Consultation And Publicity Form

Application Number: 18/01972/LB

Address: Wendlebury Lodge

Proposed second floor 1:50

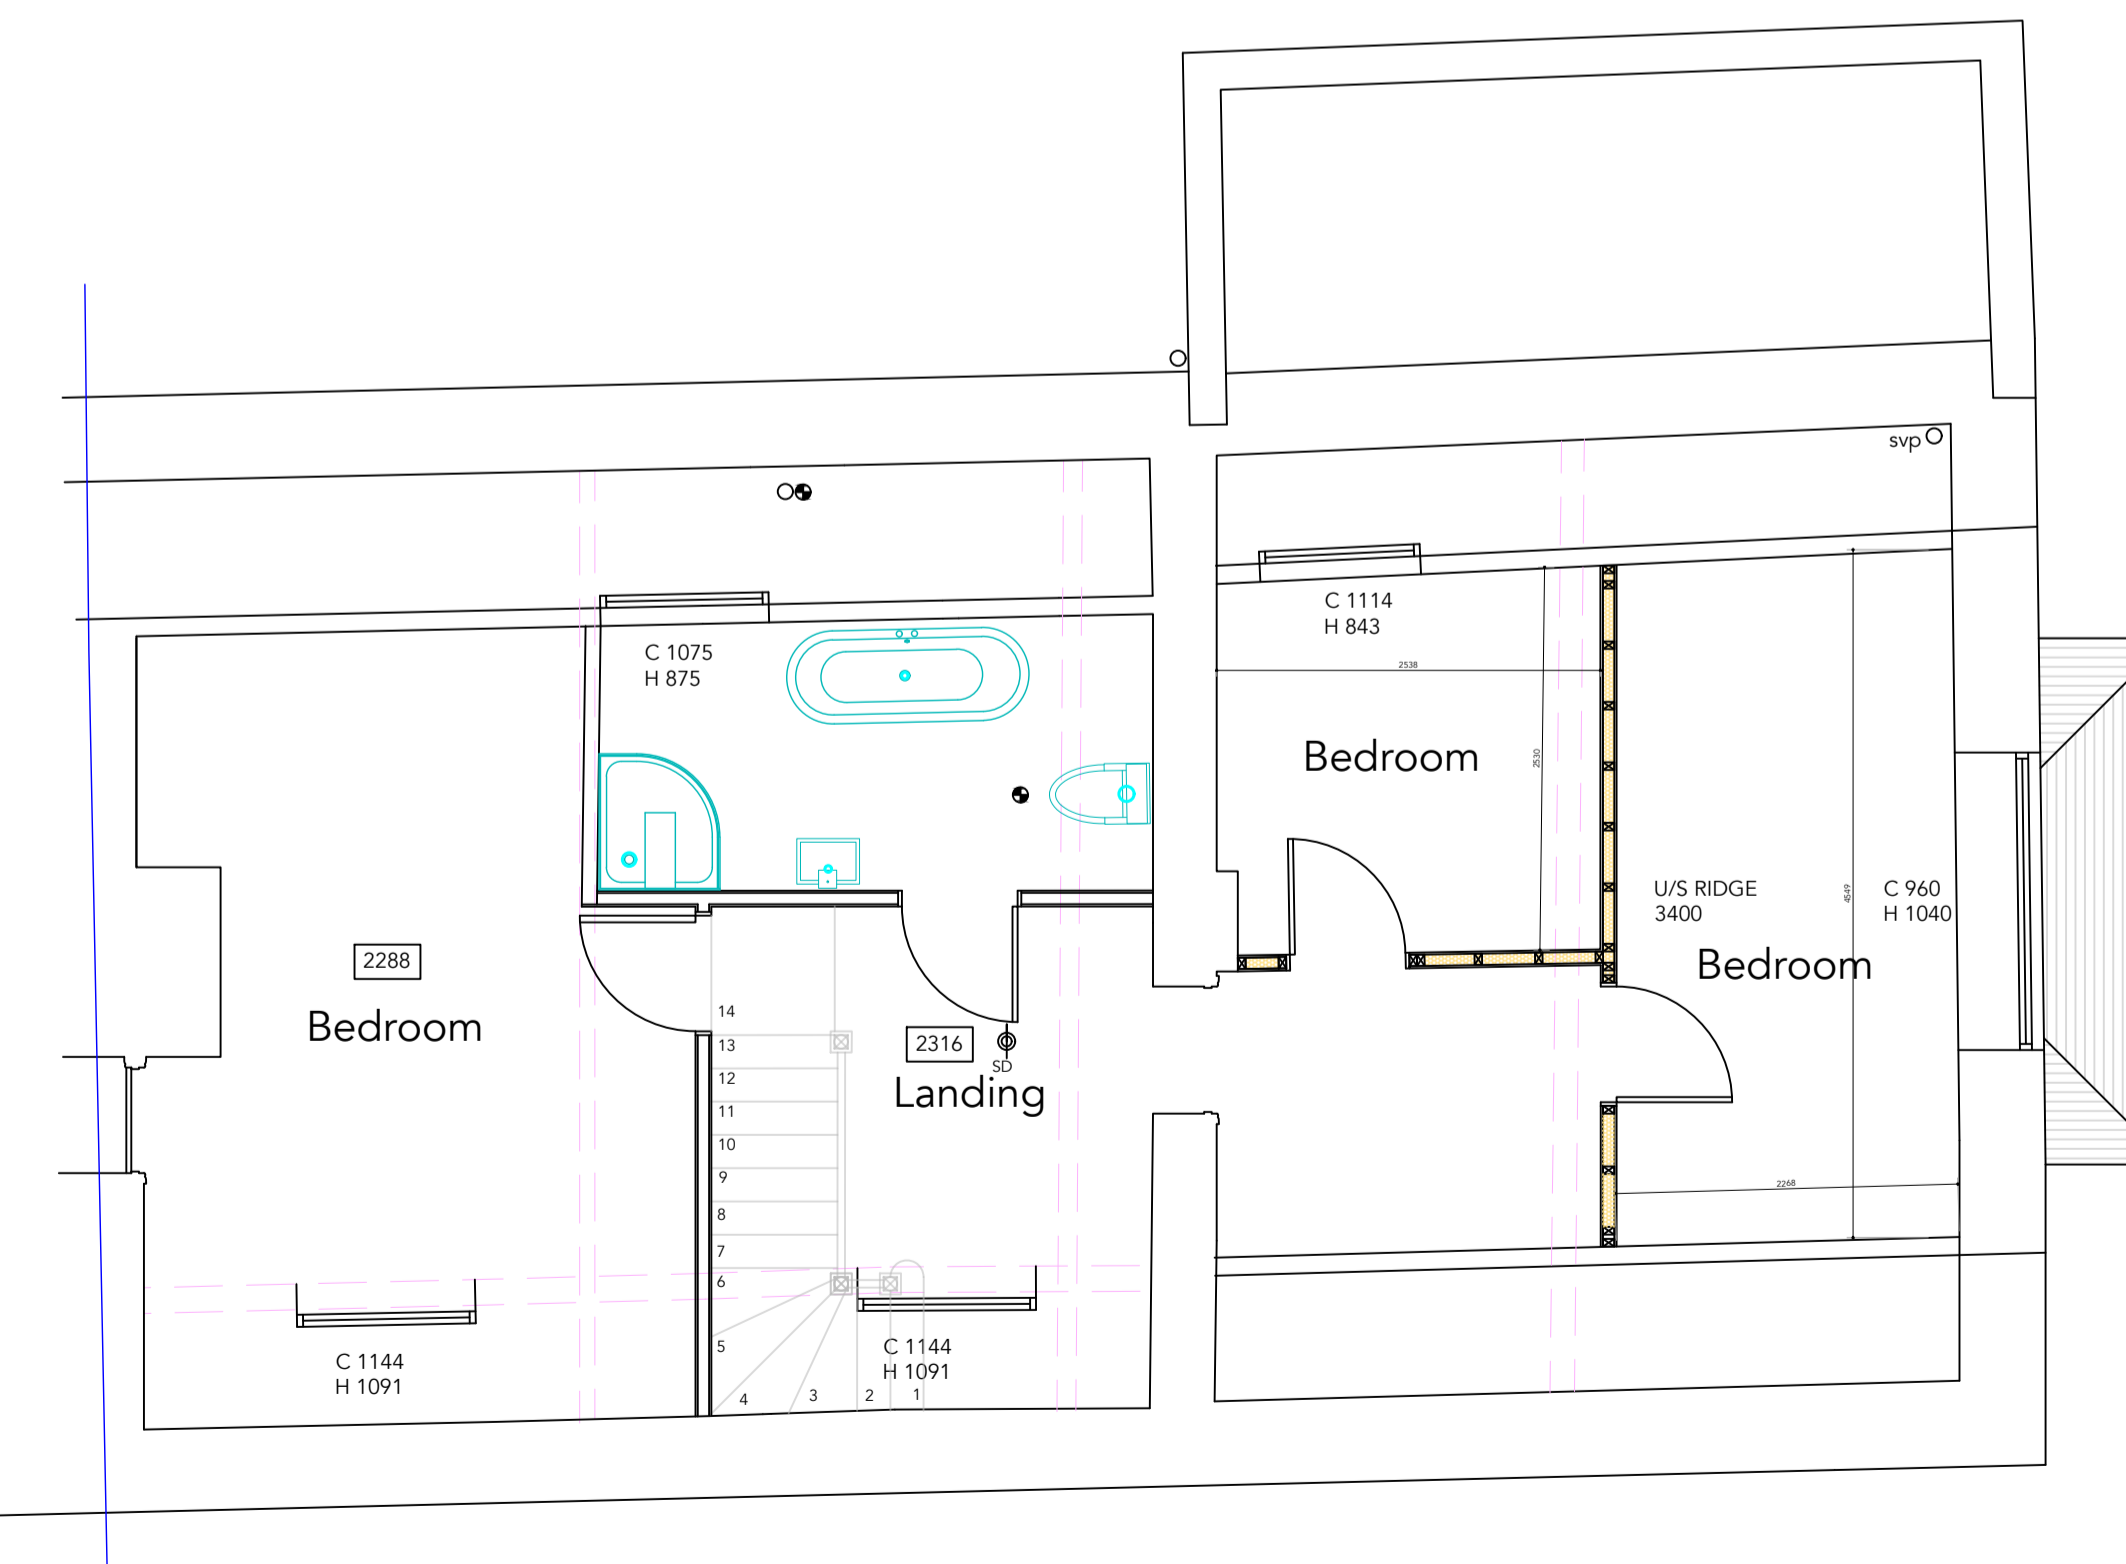
Comments for the Conservation Team: Emma has been working on this one. Emma - looks quite a straightforward reversible internal wall, however, it was double height into the existing rafters in that room – so do we need any more detail on how the walls would be inserted?
